Recommendation Report for Planning Permission for Works or Extension to a Dwelling

REF NO: AB/93/21/HH

LOCATION: 1 Stewards Rise
Arundel
BN18 9ER

PROPOSAL: Erection of a single storey side extension

DATE:	21/06/2021
SCALE:	Various
DRAWN:	SC
CHECKED:	DS
SHEET	OF
21/57	PL1
PROJECT NUMBER:	DRAWING NUMBER:
21/57	PL1
REVISION:	B

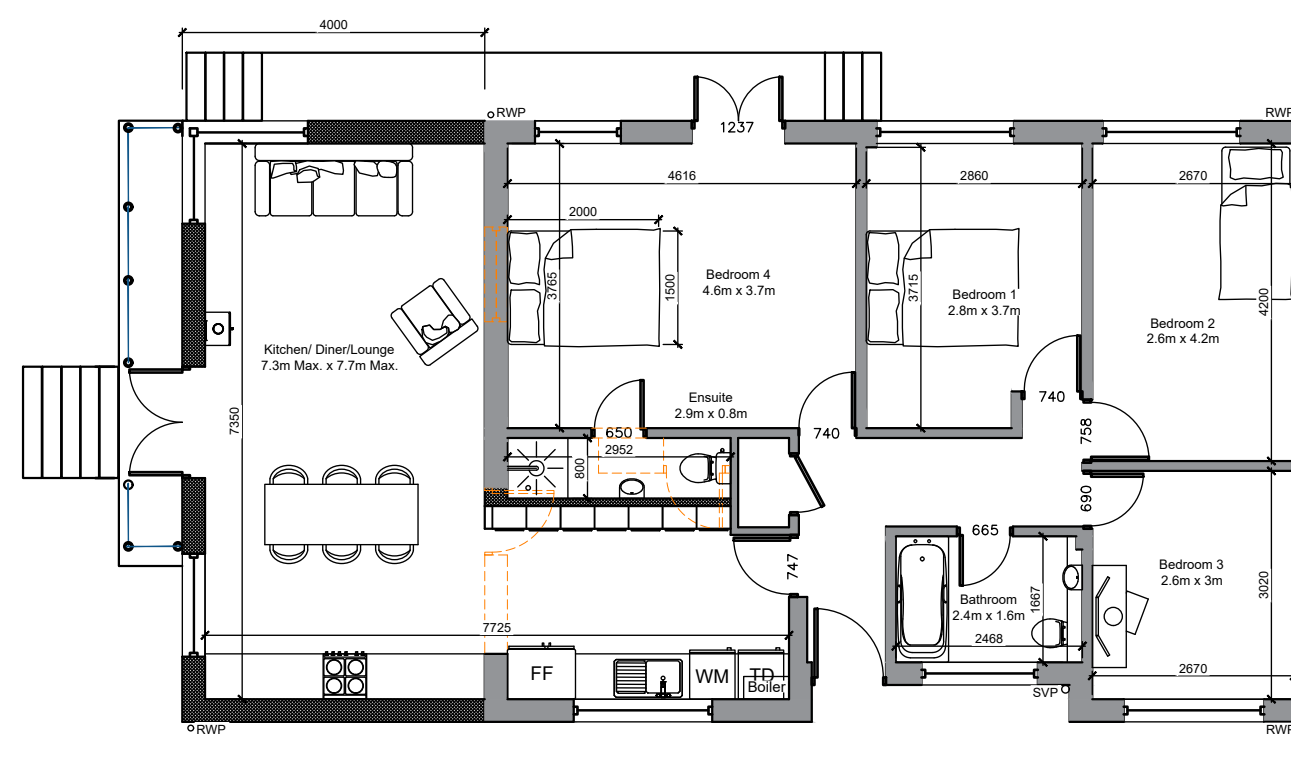
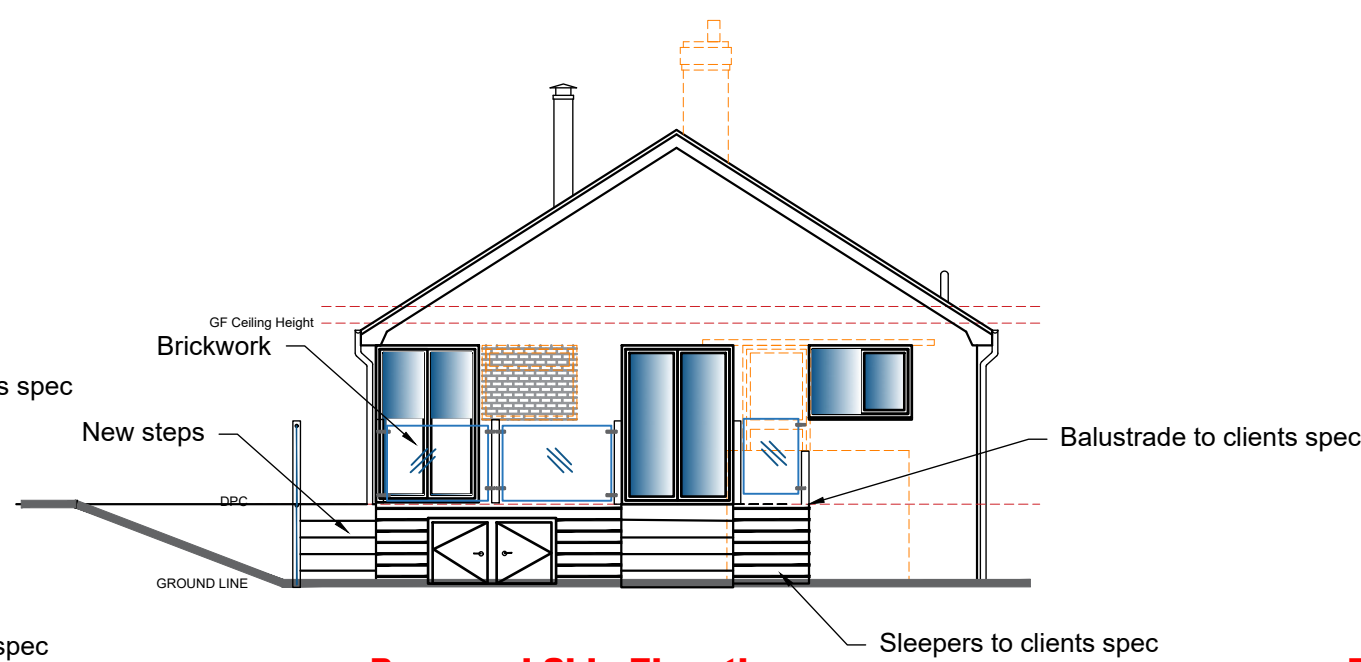
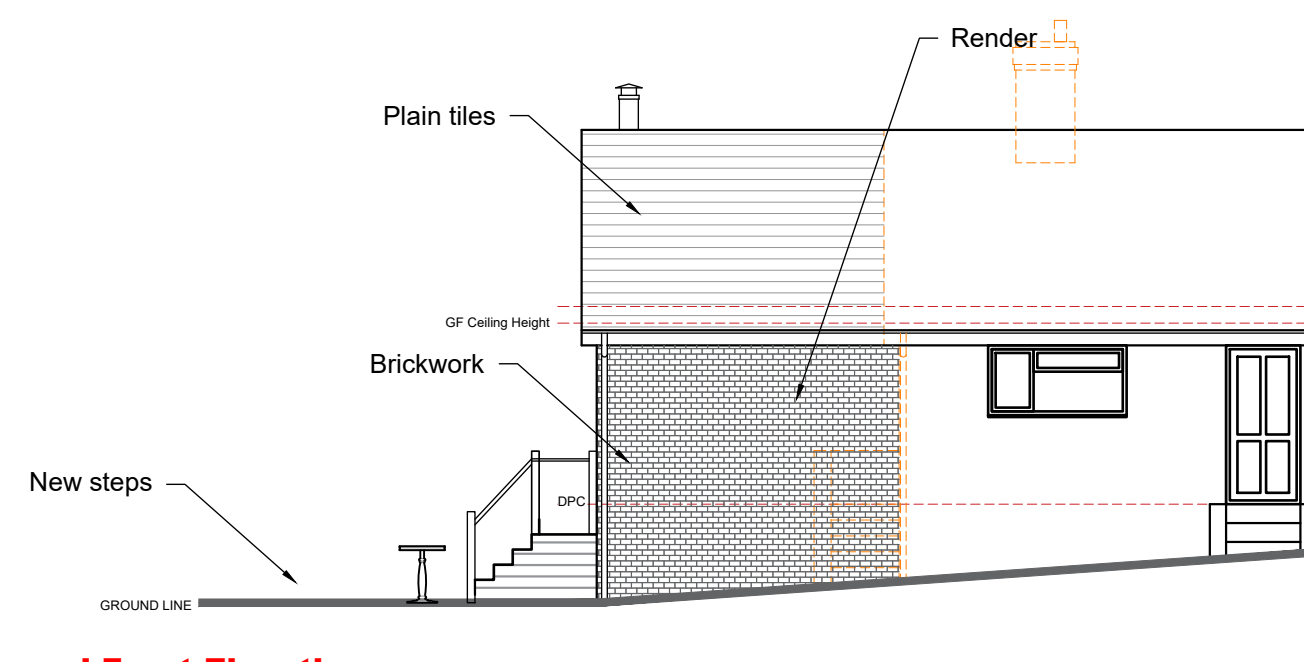
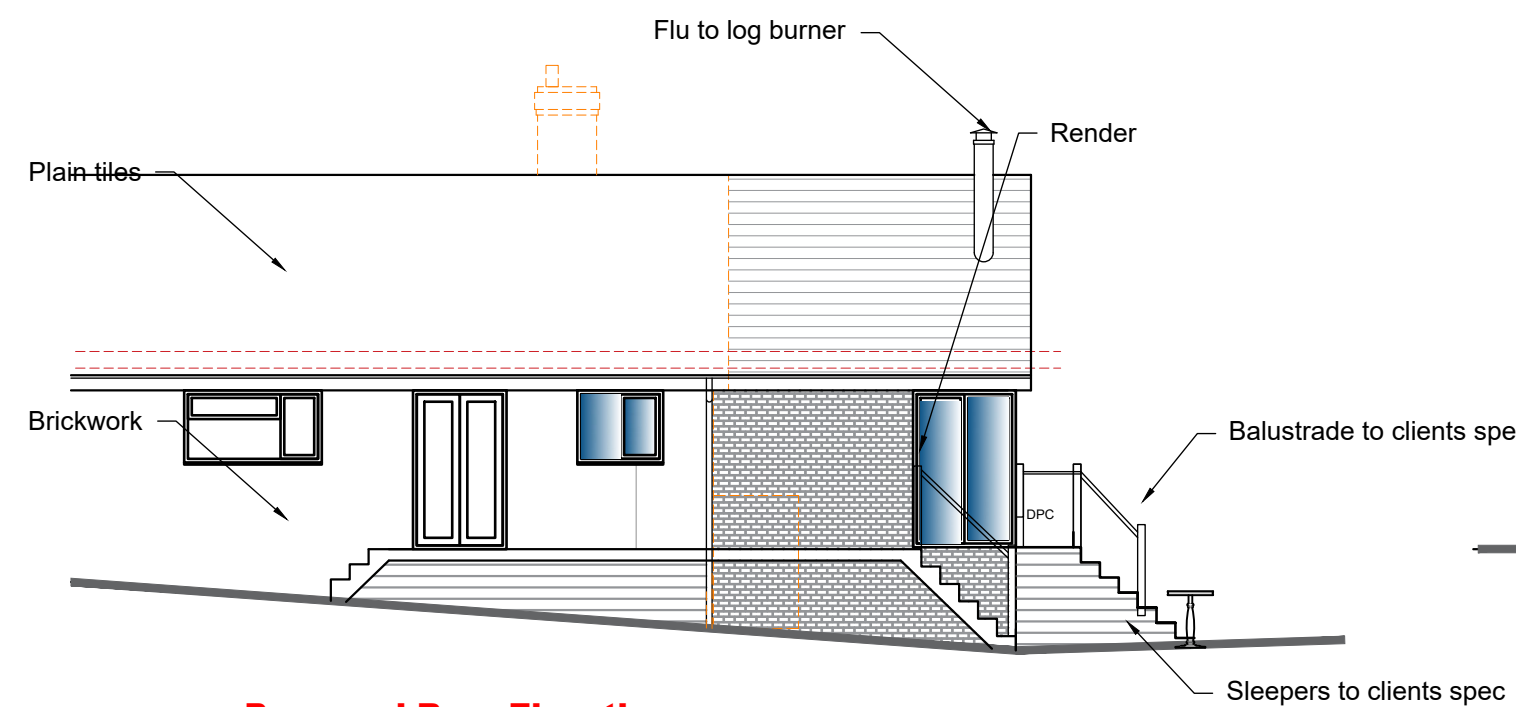
The extension has been designed to be sympathetic to the existing building though the use of materials which match those currently found on the site; and, produces a design which has a consistent form and scale with a continuing eaves and ridge line.

The extension does not dominate the original form, yet sits comfortably alongside it, although it does not attempt to be physically subservient as design guidance suggests, it is unconfontational styling means it will be subservient to the existing structure.

The extension is to be located on the eastern face of the building where, as the property is a corner plot, there are no other dwellings located, it is therefore considered not to overbear or overshadow any other property.

In terms of overlooking new fenestration would either face the side (eastern) garden or the rear of the property, which backs onto allotment gardens. As such no negative impacts from overlooking are foreseen.

of TPO/AB/1/21. The extension would encroach onto the RPA of an Oak Tree situated on the southern boundary however not to the extent to warrant refusal as long as mitigation is taken in terms of the method of construction. It has been proposed to utilise pile foundations in the construction of the extension which is acceptable. Conditions will be added to enable the correct protection and management of development within the RPA of the tree in accordance with the NPPF.

- 3 The Oak Tree denoted on plans shall not be damaged, uprooted, felled, topped or lopped without the prior written consent of the Local Planning Authority and the Landowner. The area shown on plans as the RPA shall at the commencement of construction be protected from impact, burning of materials or the storage of materials and rubbish, except for in the immediate area of works and the works shall be built in accordance with notes 'Piled Foundations' on the approved plans.
